Re, Planning Application FG59/19/H4
Pied a Terre
Ferring St BN12 5JH

I write with reference to the above application that adjoins my bungalow of 2, Onslow Drive via a party wall.

Proposed First Floor Plan

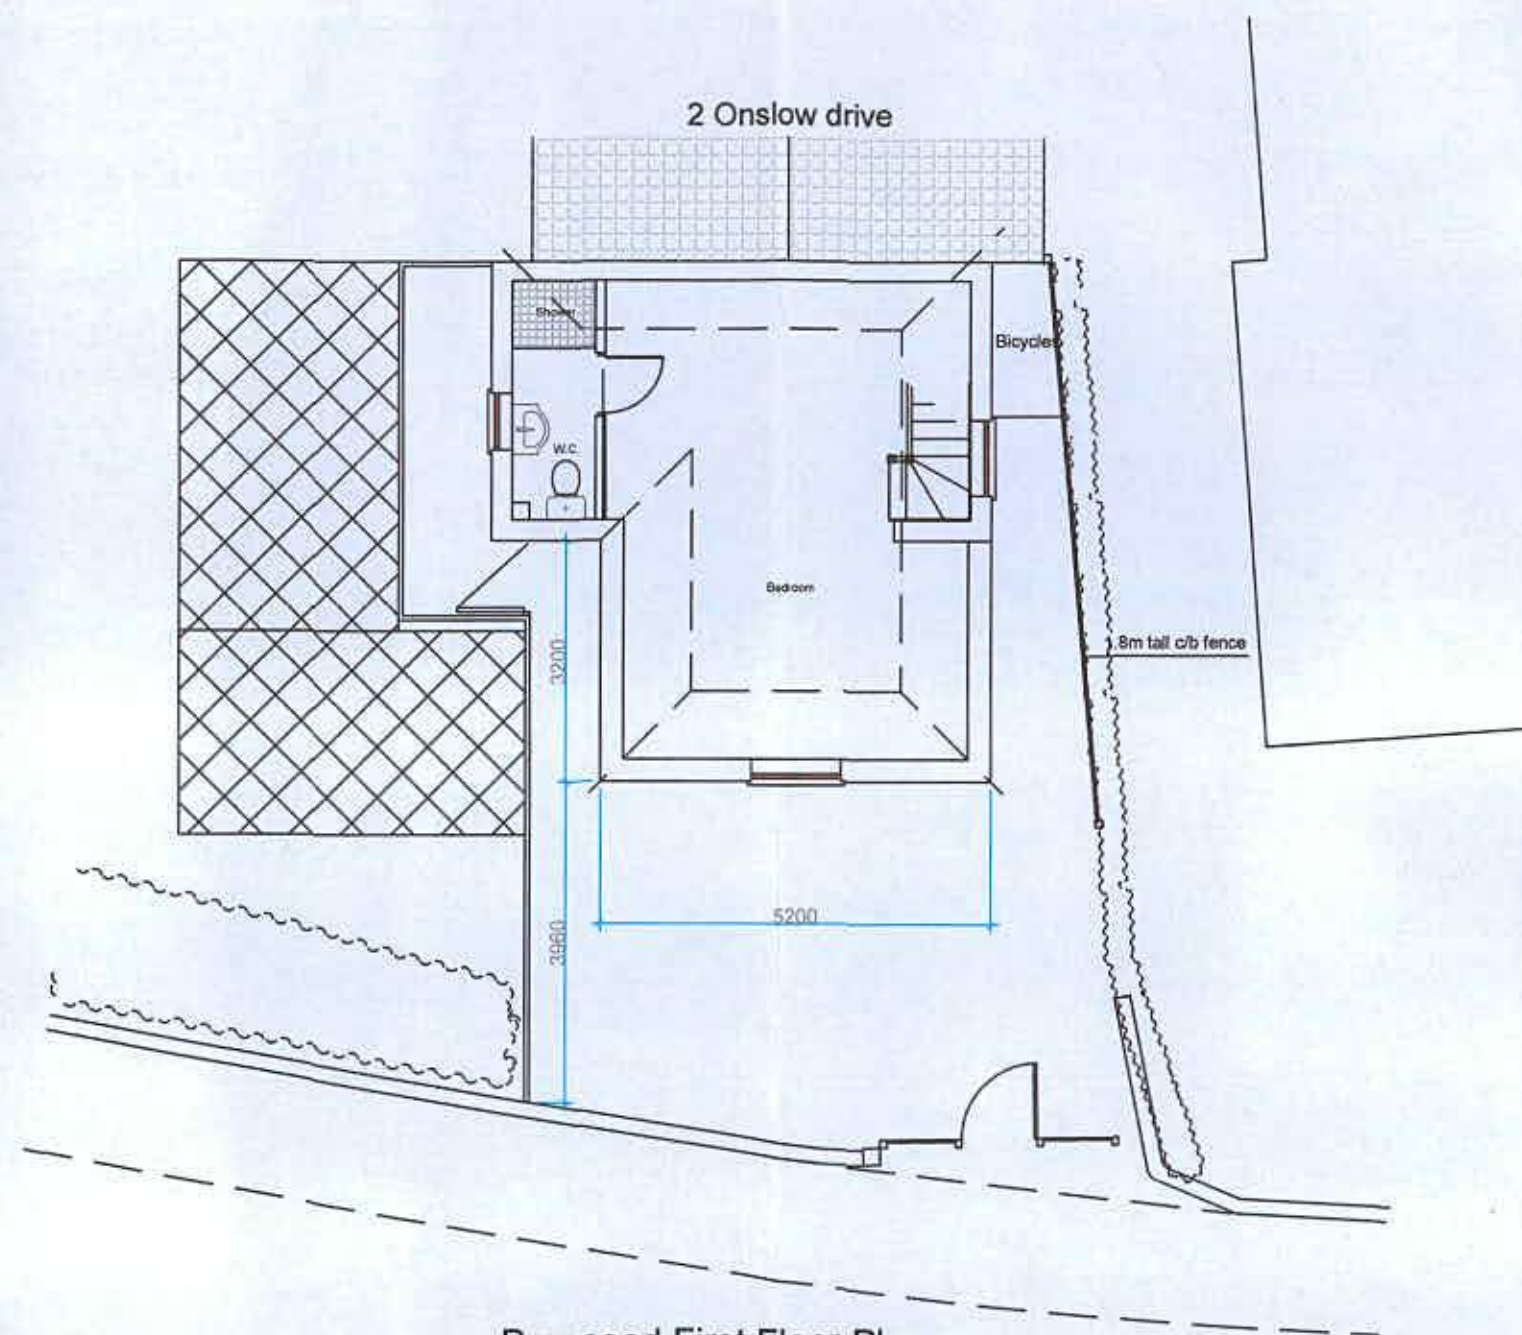
I had no objections to the first application of a ground floor storey facing east onto Ferring Street, but I strongly object to the proposal to build a 1st floor storey with pitch roof. This will be higher than my property and

Client's Name	Drawing Title	Drawn	Date
Tony Maio	Proposed Elevations/ Street Scene	FS15	15.05.19
Job Title	Scale	Rev	
Ferring Street Ferring West Sussex BN12 5JW	1:100	01

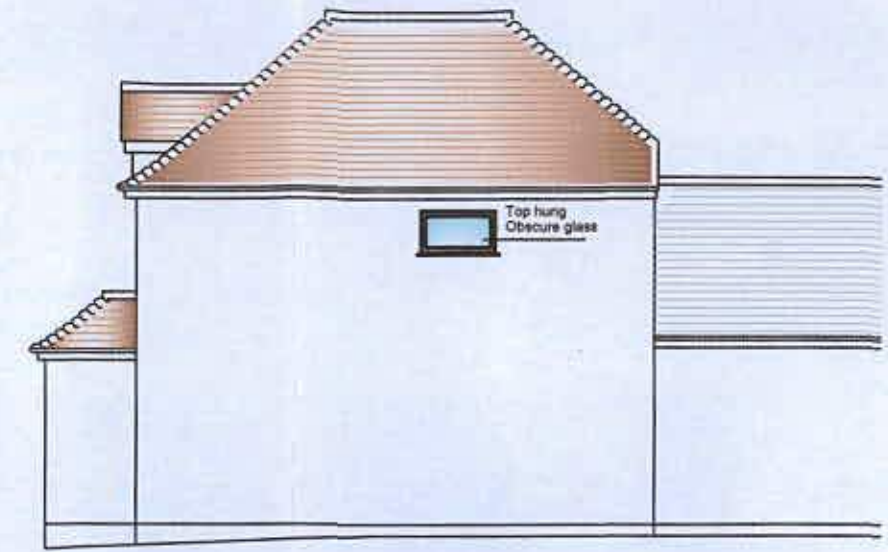
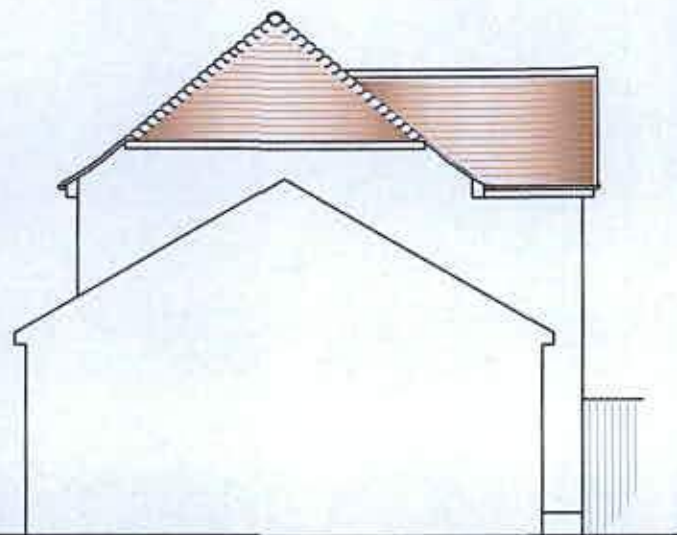
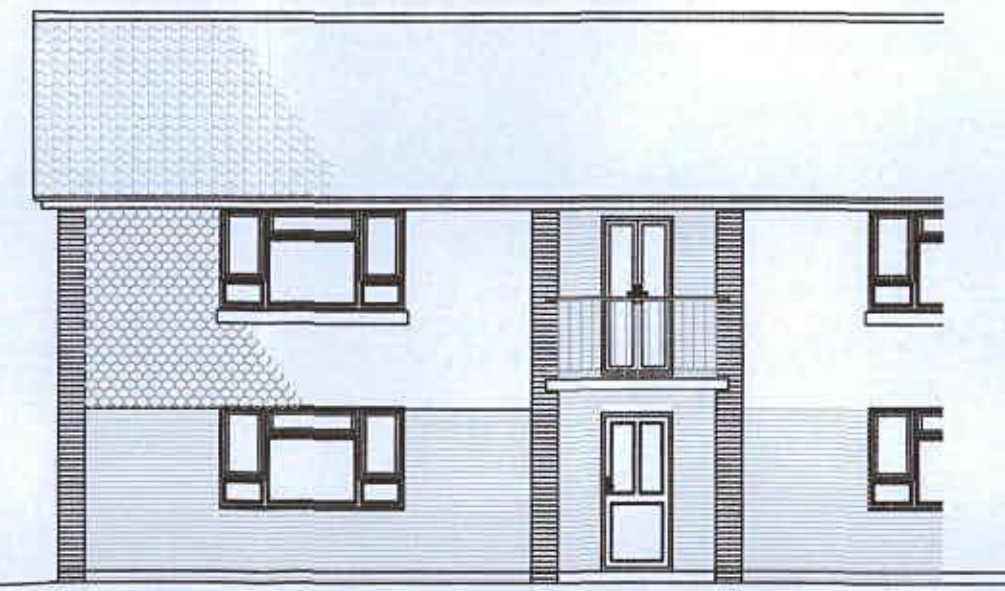
will these fence block my light and
also encroach on my privacy as it
will over look my garden and into my
bungalow, plus also affect my roof.
